CITY OF ALBUQUERQUE

December 2, 2020

**Re: Ventana Ranch Commercial Development
Traffic Impact Study**
Engineer's Stamp dated December 3, 2020 (B10D003C3)
Received 12/2/2020
CABQ Planning Transportation approved

SHEET TITLE: SITE PLAN

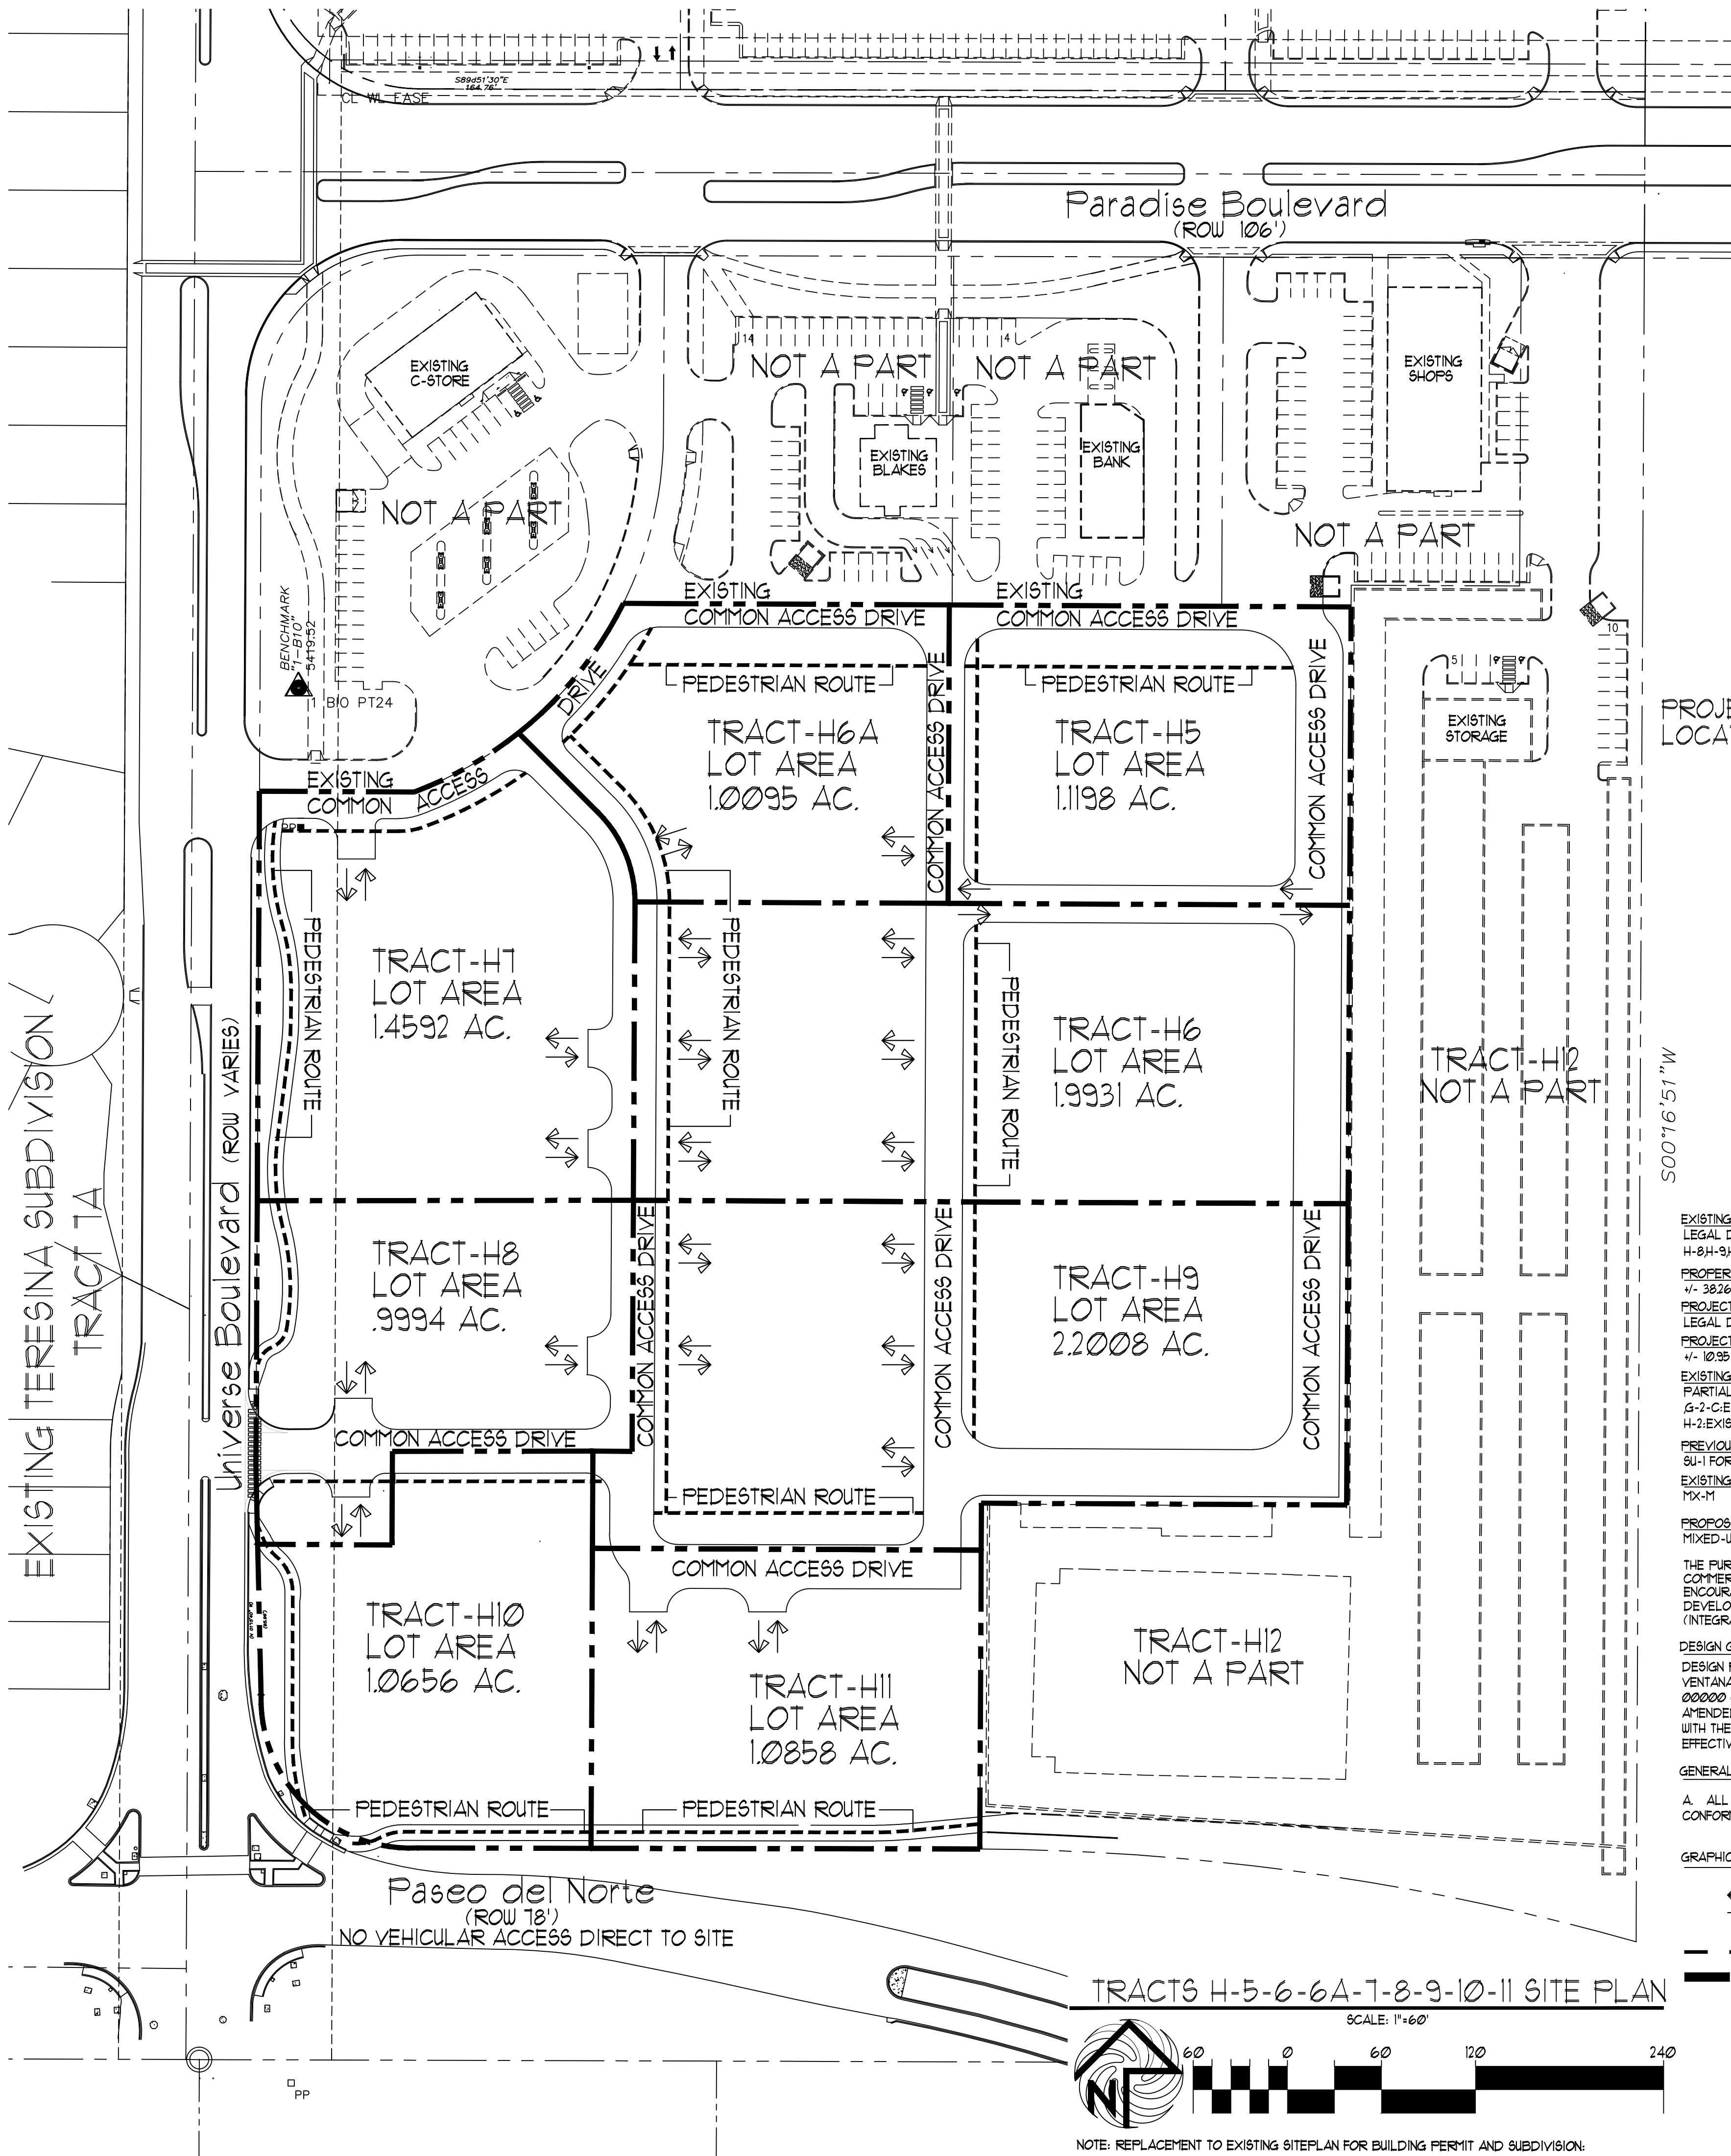
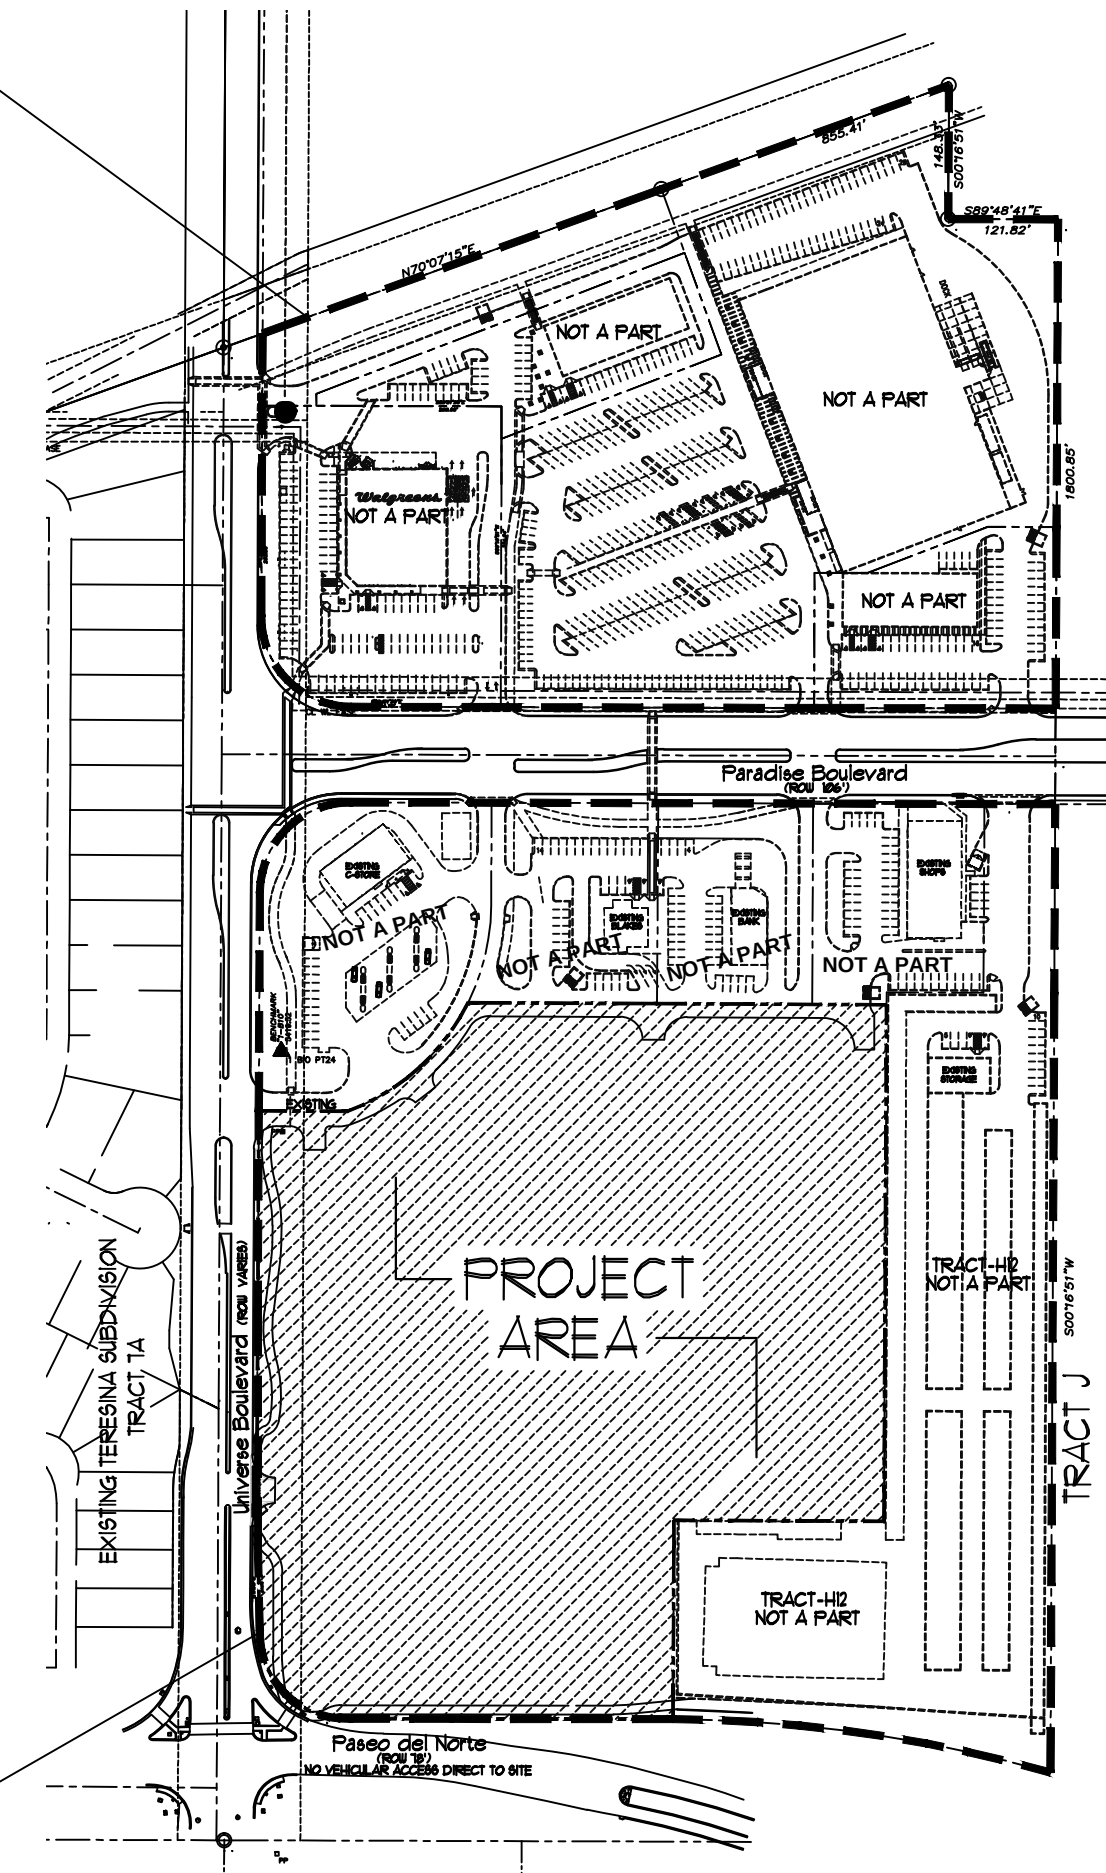
1. EAST Driveway (Intersection 7) – Construct an 11-foot wide eastbound right-turn deceleration lane at least 250-feet long including a 150-150-foot reverse curve transition.
2. WEST Driveway (Intersection 8) – Construct an 11-foot wide eastbound right-turn deceleration lane at least 180-feet long including a 150-150-foot reverse curve transition.
3. NORTH Driveway (Intersection 9) – Construct an 11-foot wide northbound right-turn deceleration lane at least 300-feet long including a 150-150-foot reverse curve transition
4. SOUTH Driveway (Intersection 10) – Construct a northbound right-turn taper lane at least 100-ft long and an 8:1 taper. Reconstruct and relocate existing median cut to align with proposed driveway. The centerline of existing median cut is approximately 85-feet north of the centerline of the proposed driveway.
